RE: PICTON HIGH SCHOOL RESPONSE TO SUBMISSIONS – RMS COMMENTS

We write with regard to Picton High School Redevelopment (SSD 17_8640), specifically in response to your email dated 12 December 2018 requesting responses to comments raised by RMS following the lodgement of the Response to Submissions package (dated 30 October 2018).

RE: PICTON HIGH SCHOOL RESPONSE TO SUBMISSIONS

Picton High School
Swept Path Assessment
On-site Bus Parking

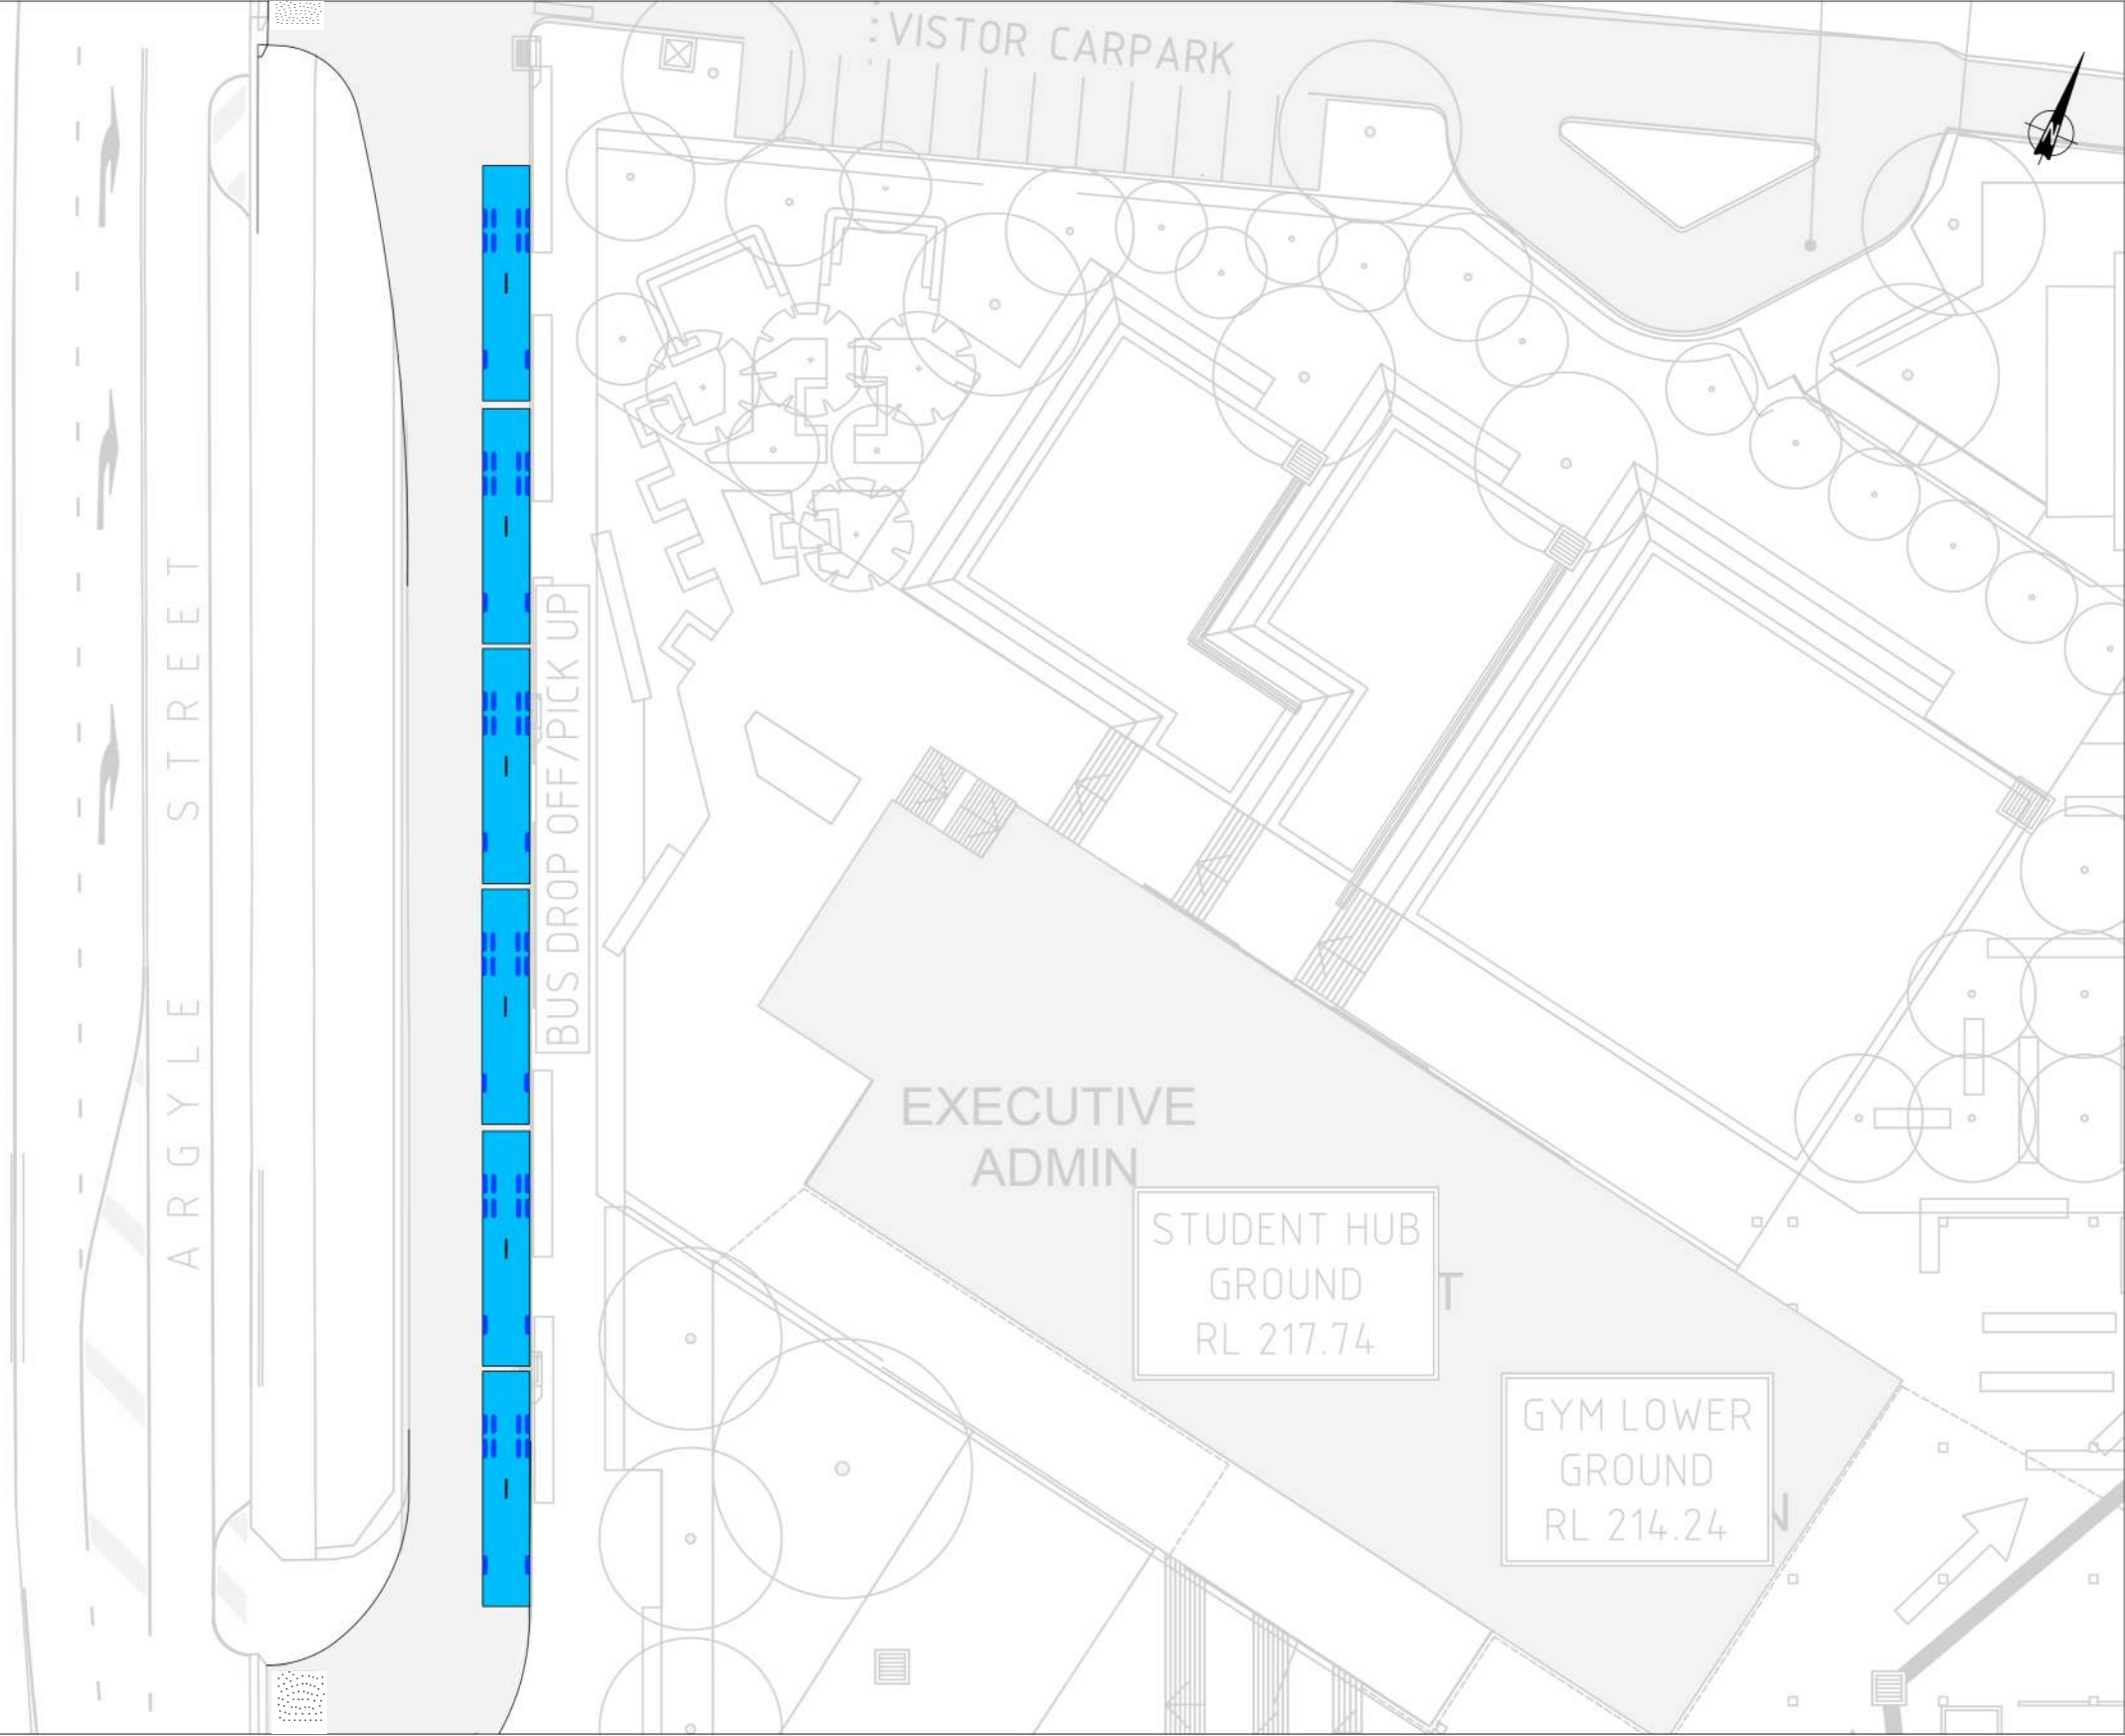
<p>Swept Path Assessment</p> <p>RMS notes that the updated <i>Traffic and Accessibility Impact Assessment</i> (prepared by TDG, Ref: 14584 ta 180803 final, dated 3 August 2018) contains updated turning manoeuvres for buses entering and leaving the site. As detailed in RMS' previous advice the plans provided should comply with Austroads requirements (e.g. speeds used, required clearances, etc). The following comments are provided on the updated plans:</p> <ul style="list-style-type: none"> • The turning path for the bus entering the bus parking area fronting Argyle Street from the north does not appear to have been applied correctly. The radii used are too tight with the vehicle turning at too low a speed. If applied correctly the bus would not be able to park in the last parking space without reversing and manoeuvring into the position; • The bus turning from the right turn bay cannot enter the parking area without the front overhang crossing onto the footpath; • The turning path for the bus exiting the bus parking area to the north has not been applied correctly. The radii used are too tight with the vehicle turning at too low a speed; 	<p>As shown in Attachment B (swept path analysis at 5km/h) this will be the maximum design bus that will be used on-site. The bus access arrangement has been revised to avoid the front overhang.</p> <p>The bus vehicle turning path has been designed in accordance with the 'Austroads 2013 – Design Vehicles and Turning Path Templates Guide'.</p> <p>As specified in the Austroads Guide, the long rigid bus of 14.5 metres long, is designed to a speed of 5km/h.</p> <p>In addition, we have also prepared the bus movement at a design speed of 10km/h (refer to Attachment C).</p> <p>The bus operations (loading and unloading of students) will be managed by staff to ensure students get on the correct bus service, and fill up the first bus before proceeding with the second bus.</p>

Issue	Response
<ul style="list-style-type: none"> When the turning paths are applied correctly a bus is unable to enter the bus parking area if another bus is occupying the end parking space. This could cause queuing onto Argyle Street; If the number of buses shown within the Argyle Street bus pick up/drop off area are to be contained within this area then they would have to exit in the same order as they arrive (i.e. no space between the buses to allow them to manoeuvre into or out of their space if other buses are occupying the adjacent spaces). This has the potential to cause congestion which will impact upon the operation of Argyle Street; <p>Noting the comments above RMS believes that the applicant should be requested to provide the above detail to council for review and comment prior to the determination of SSD 8640.</p>	
School Zones	
<p>RMS notes that the RTS covering letter prepared by Ethos Urban (dated 30 October 2018) details, in part, that the determination of the school zones required (i.e. new school zone and/or amendments to the existing school zone) will be addressed following approval of the current SSD application. While this is correct, it has now become apparent that a temporary school is being established on the site with access to be gained from Wonga Road. The details of the temporary school were not discussed in any detail in the information that has been provided to date. While RMS acknowledges that the temporary school does not form part of the current SSD application, if it is intended to occupy the temporary school at the start of the 2019 school year RMS advises that the new school zone for Wonga Road and associated speed zone reductions will need to be in place before the commencement of use of the temporary school. The new school zone in Wonga Road to be determined in consultation with RMS's Road User Safety Project Officer. It is therefore requested that DPE inform the applicant that they should make contact with Amanda Priestley at RMS on 4221 2517 to further progress the new school zone that will be required in Wonga Road to service the proposed temporary school.</p>	<p>Stephen Craig from Taylor Construction has contacted Amanda Priestley regarding the School Zones on Wonga Road (refer to Attachment D). A concept School Zone plan has been prepared (refer to Attachment E).</p>
